### **DEPARTMENT OF PUBLIC WORKS**

**RE:** Rockberry Final Plat

Public Works has reviewed the final plat submitted for Rockberry Loop (LPF-19-00001). Our comments appear below for your consideration.

DWN BY	DATE	JOB NO.
D.L.P./G.W.	04/2019	16078
CHKD BY	SCALE	SHEET
D.L.P.	1" = 100'	2 OF 6

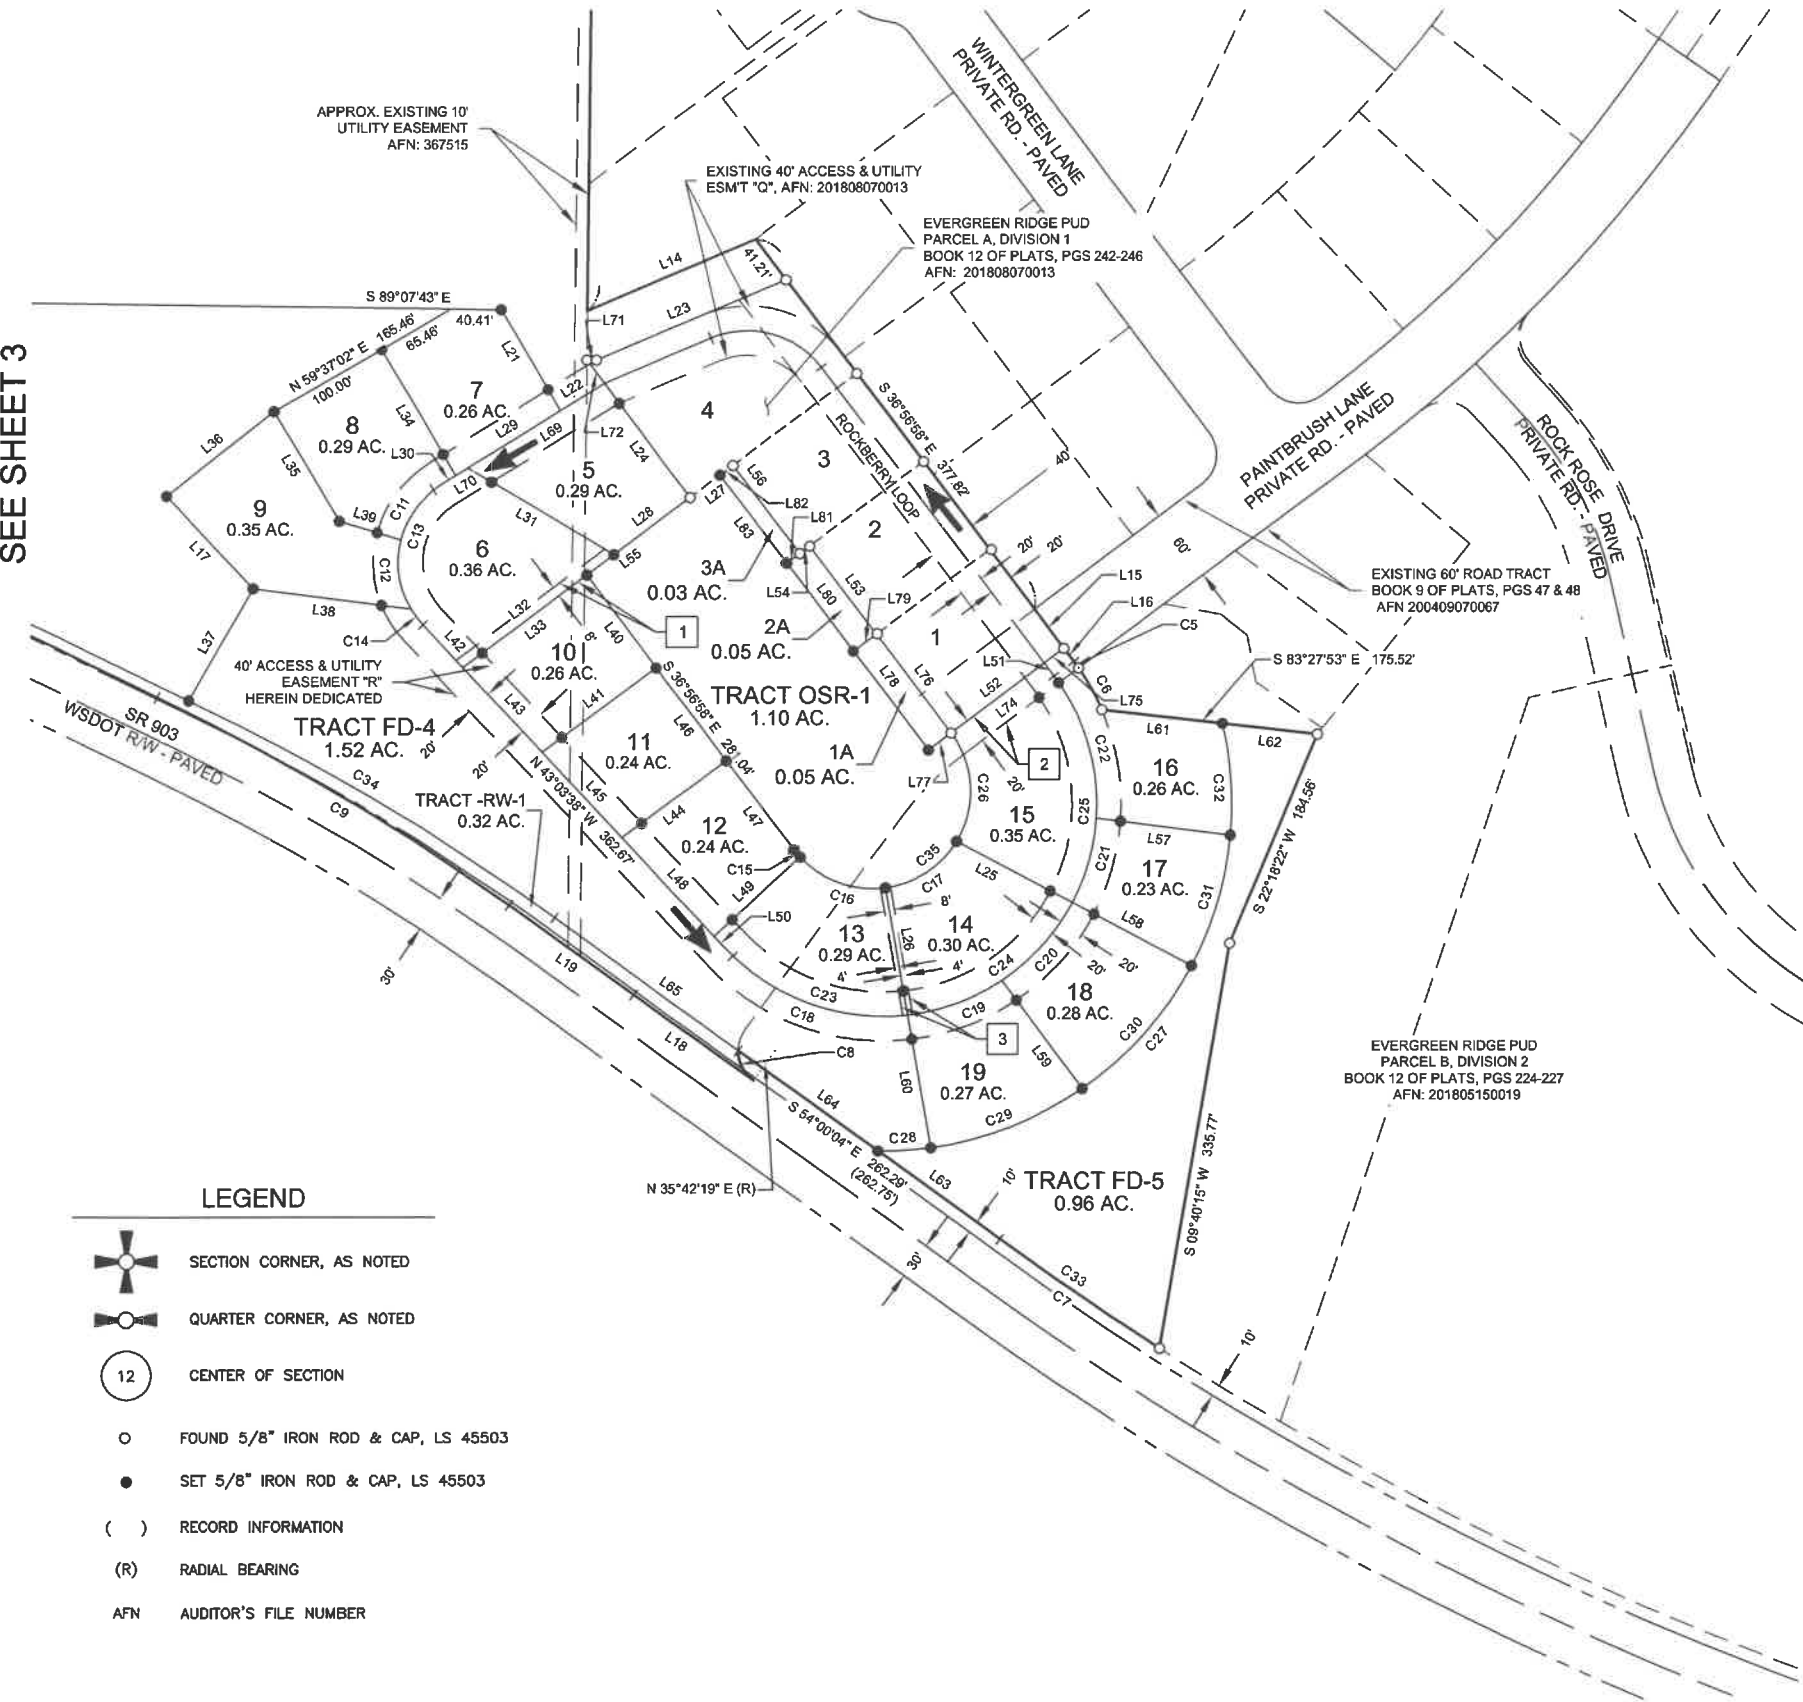
1. Kittitas County Road Standards do not contemplate a “one way” road. The proposed right of way width of 40 feet appears sufficient in the absence of a standard. The road shall be a minimum width of 20 feet with one foot shoulders.
2. Prior to final approval of any land use development activity, a performance guarantee is required.
3. A stormwater management plan meeting the current requirements of the Eastern Washington Stormwater Manual (WA DOE) is required prior to any land use development activity.
4. “Double O Road” easement width and road standard shall be resolved to the satisfaction of Kittitas County Department of Public Works prior to any land use development activity.
